PLANNING AMENDMENT

APPLICANT NAME AND ADDRESS IAN BUCKLEY 145, BOURNE ROAD SPALDING PE11 3LJ Telephone: [REDACTED]		AGENT NAME AND ADDRESS DEREK BUCKLEY 20 CHURCHFIELDS AUDENSHAW MANCHESTER M34 5HZ Telephone: 07525 143 171	
SITE ADDRESS DETAILS 145, BOURNE ROAD, SPALDING. PE11 3LJ.			
CURRENT APPLICATION NO: This amendment cannot be considered unless the relevant reference is stated.		H16-0803-21	
Building Regulation reference relating to same development (if applicable)		N/A

2 STOREY FRONT EXTENSION
AND SINGLE STOREY REAR
AND FIRST FLOOR SIDE
EXTENSION AND LOFT

CONVERSION WITH REAR
DORMER INC. ROOF
RE-DESIGN, DETACHED
GARAGE AND REPLACE
SEPTIC TANK

Proposed Section Through

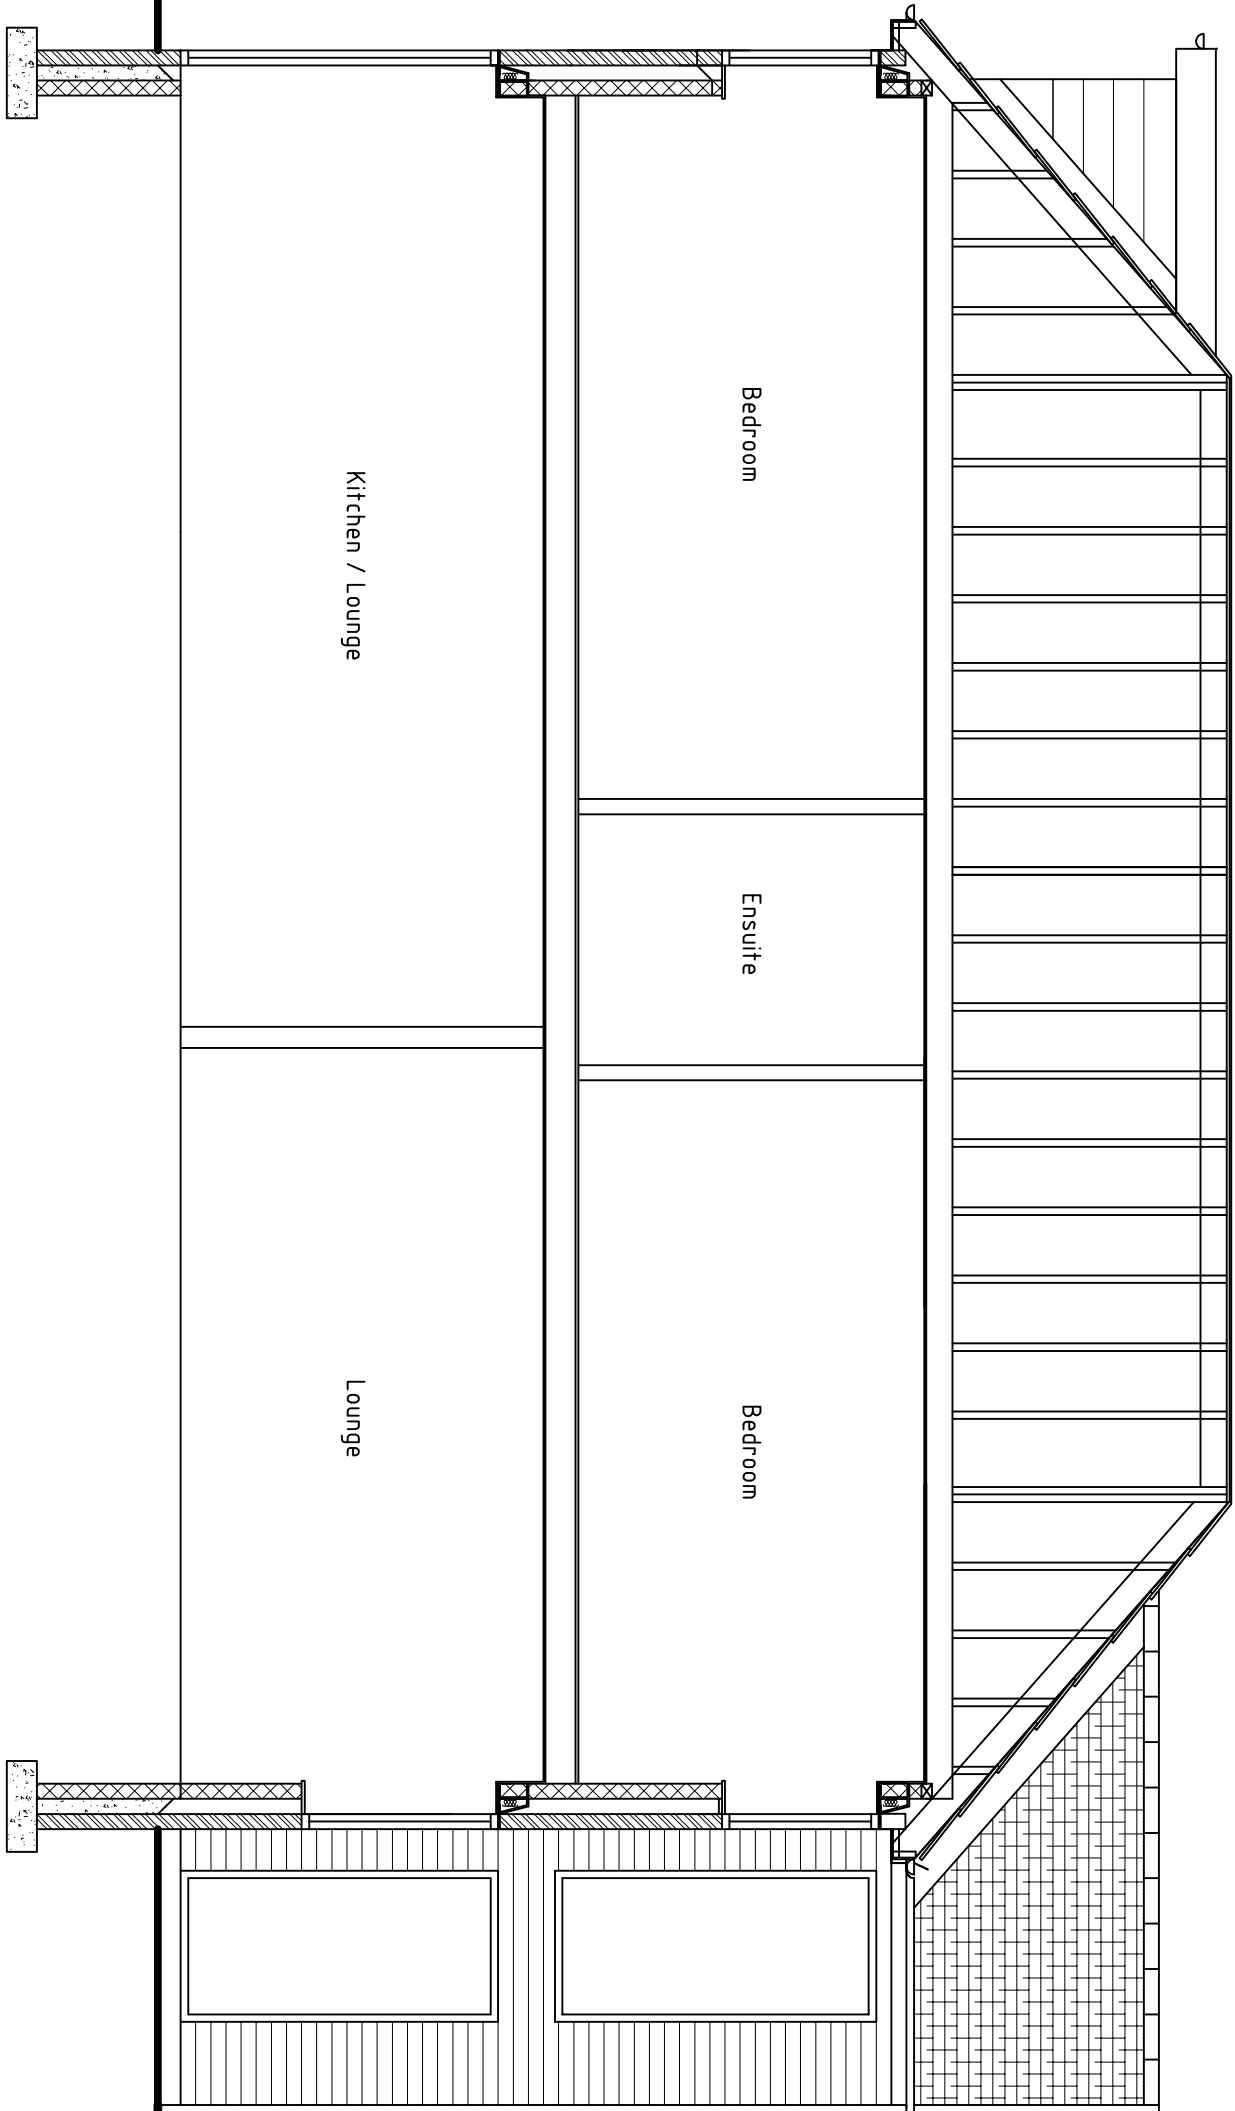
→ AMENDMENT : REAR EXTENSION TO BE 2 STOREY.
INCREASE IN ROOF SPACE.
